Ribble Valley Borough Council
Housing & Development Control

Application number: **2020.0307.FULL**

Address: **Land south west of Ribblesdale Hall Sawley Road, Chatburn**

Proposal: **Proposed change of use of agricultural land for the development of a holiday park containing 9 lodges and a manager's lodge with associated access and landscaping.**

SHEET:
PROPOSED SITE PLAN DETAILED

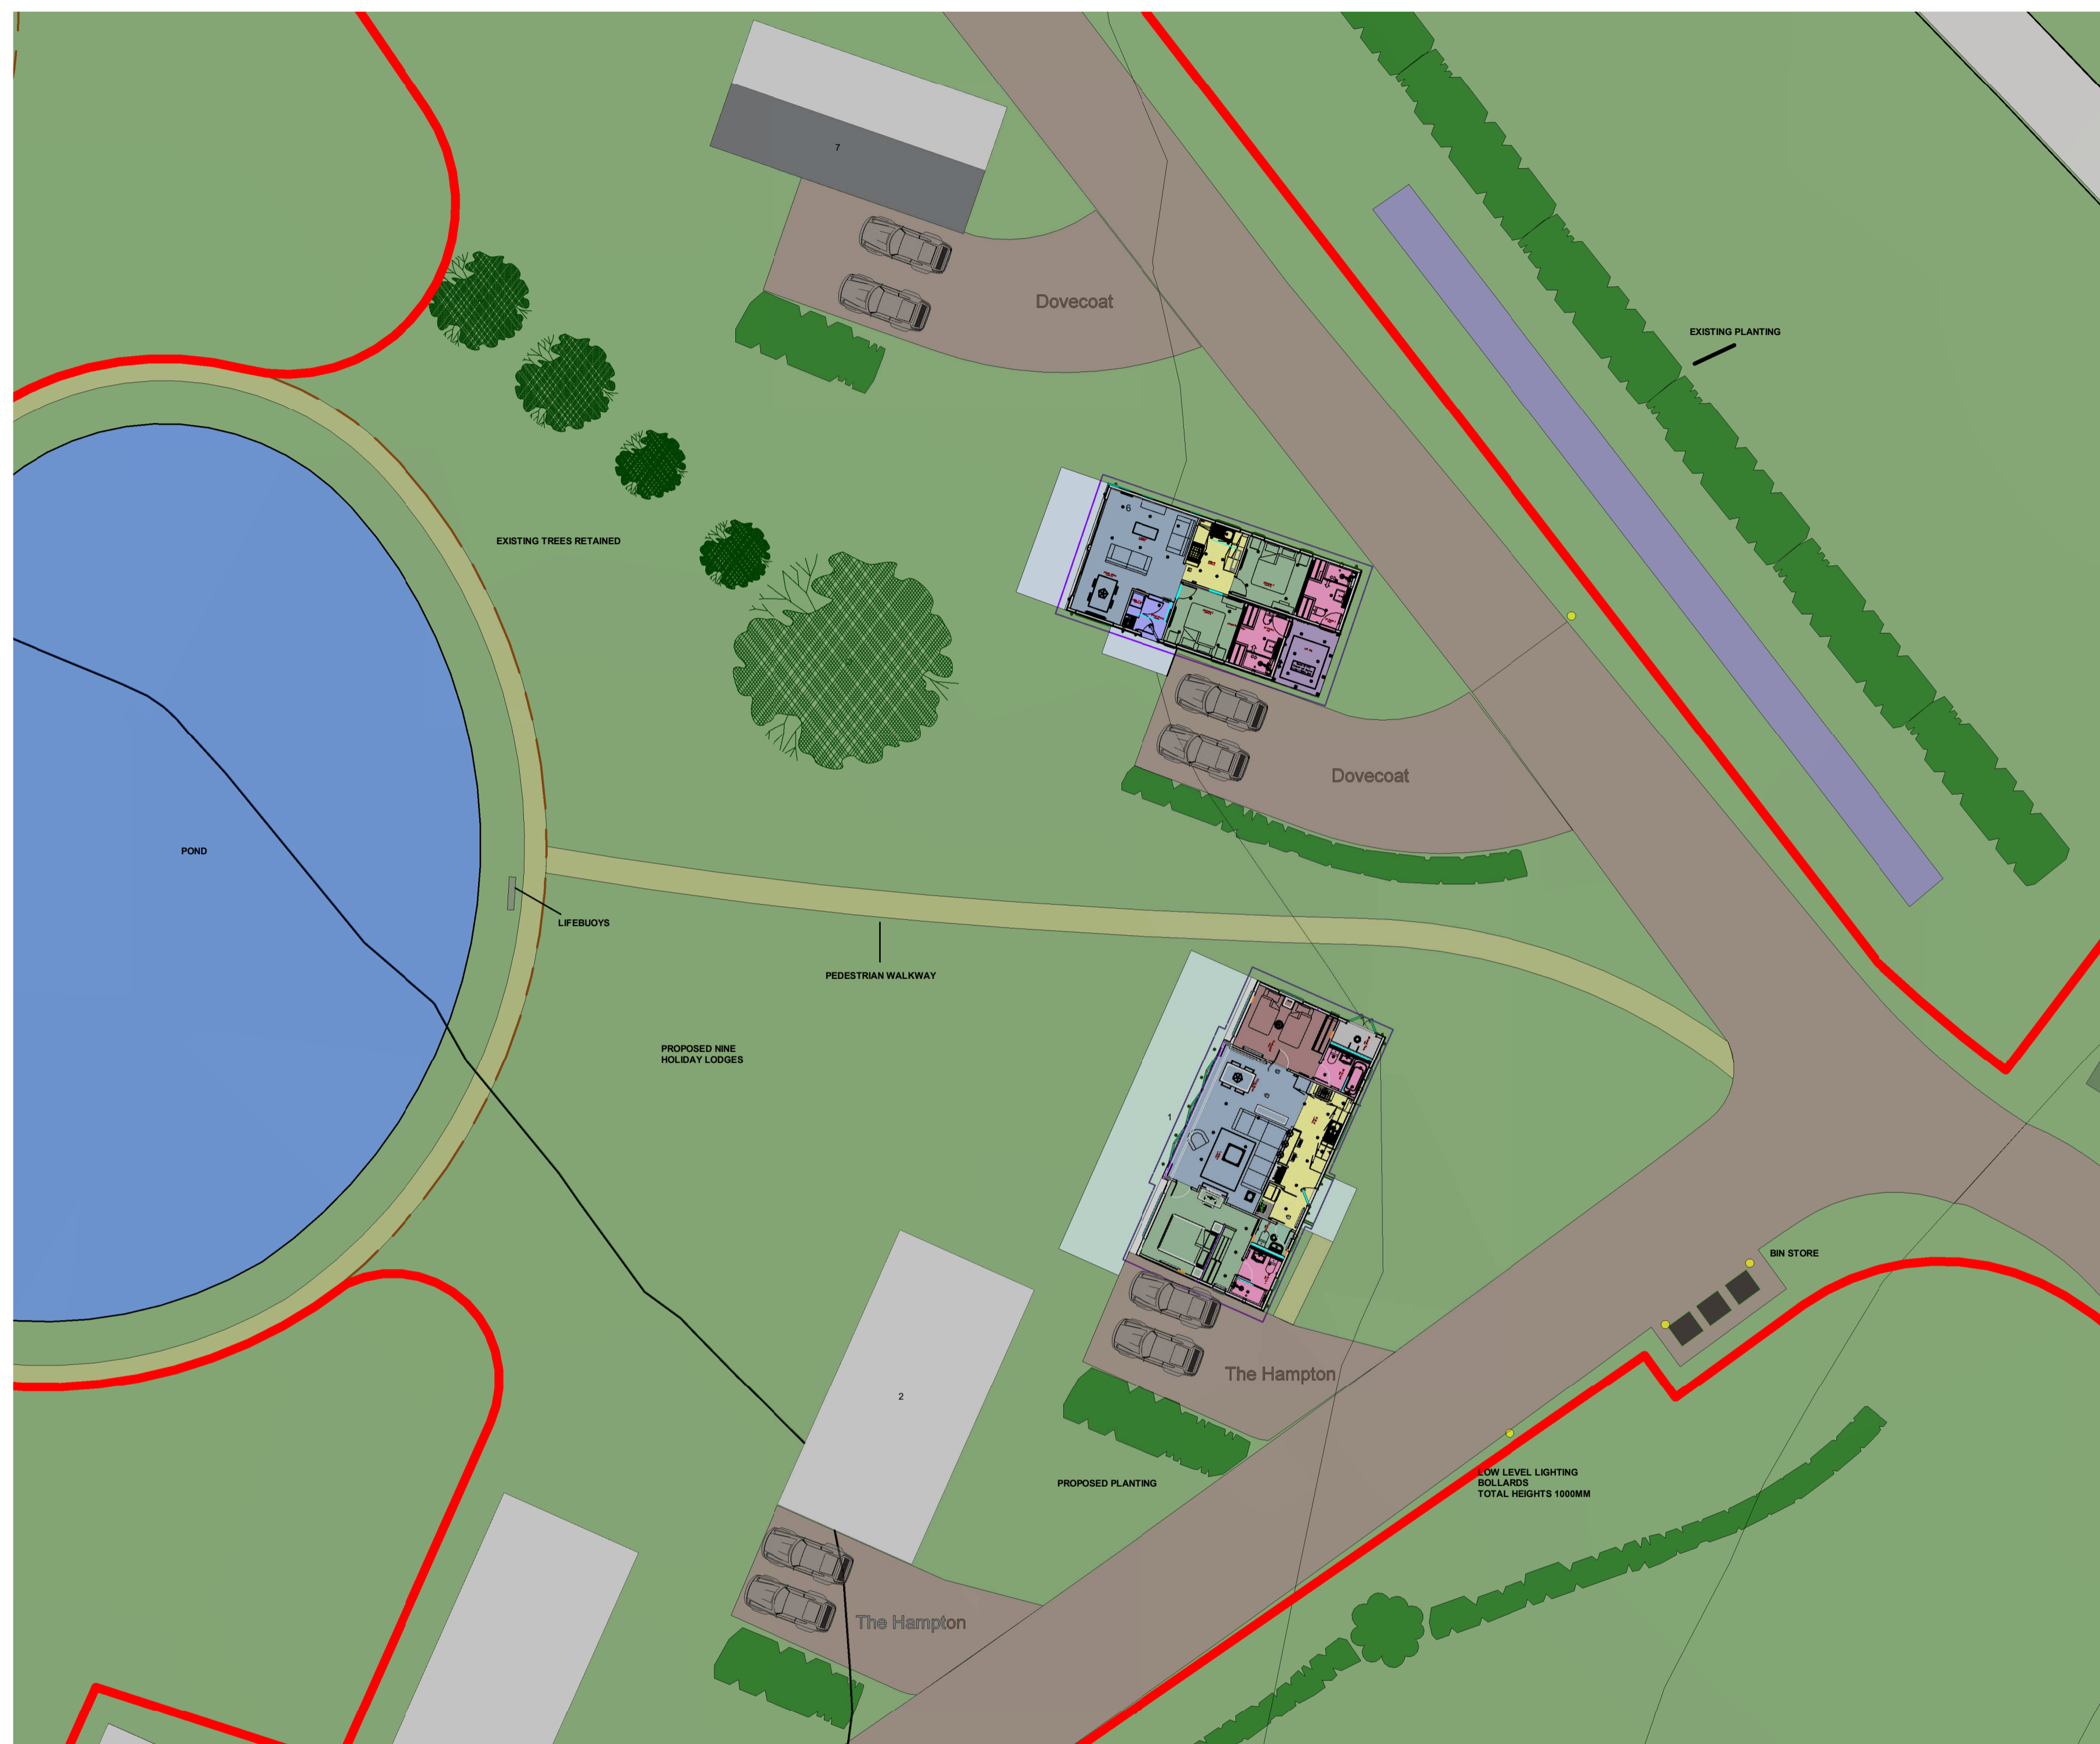
While I can confirm that there are no valid highway reasons to object to the applicant's proposal, given the sites location in a rural environment it is important that measures are included within any proposed development of the site to formalise the existing "field gated" point of access to include:

- Creation of an oversized length of driveway to allow two vehicles to pass unhindered prior accessing / egressing to / from the adjacent public highway.
- Laying of metaled surfacing
- Undertaking a degree of vegetation / boundary hedgerow management along the frontage of the site with Sawley Road point of access.

1. The proposed access from the site to Sawley Road shall be constructed to a (minimum) width of 7 metres and this width shall be maintained for a minimum distance of 10 metres

measured back from the nearside edge of Sawley Road carriageway vehicle running lanes. Reason: To enable vehicles to enter and leave the premises without conflict, unhindered & in a safe manner without causing a hazard to other road users.

3. Before the access is used for vehicular purposes that part of the access extending from the highway boundary for a minimum distance of 10m into the site shall be appropriately paved using a permeable form of bitumen macadam, concrete, block pavements, or other approved materials. Reason: To prevent loose surface material from being carried on to the public highway thus causing a potential source of danger to other road users.

4. Before the access is used for vehicular purposes, any gateposts erected at the sites point of access with Sawley Road shall be positioned behind the nearside edge of an established field boundary hedge line with associated gates opening away from the highway. Reason: To permit vehicles to pull clear of the carriageway when entering the site and to assist visibility.

I would recommend that the applicant undertake a degree of vegetation / hedgerow management along the sites frontage with Sawley Road.
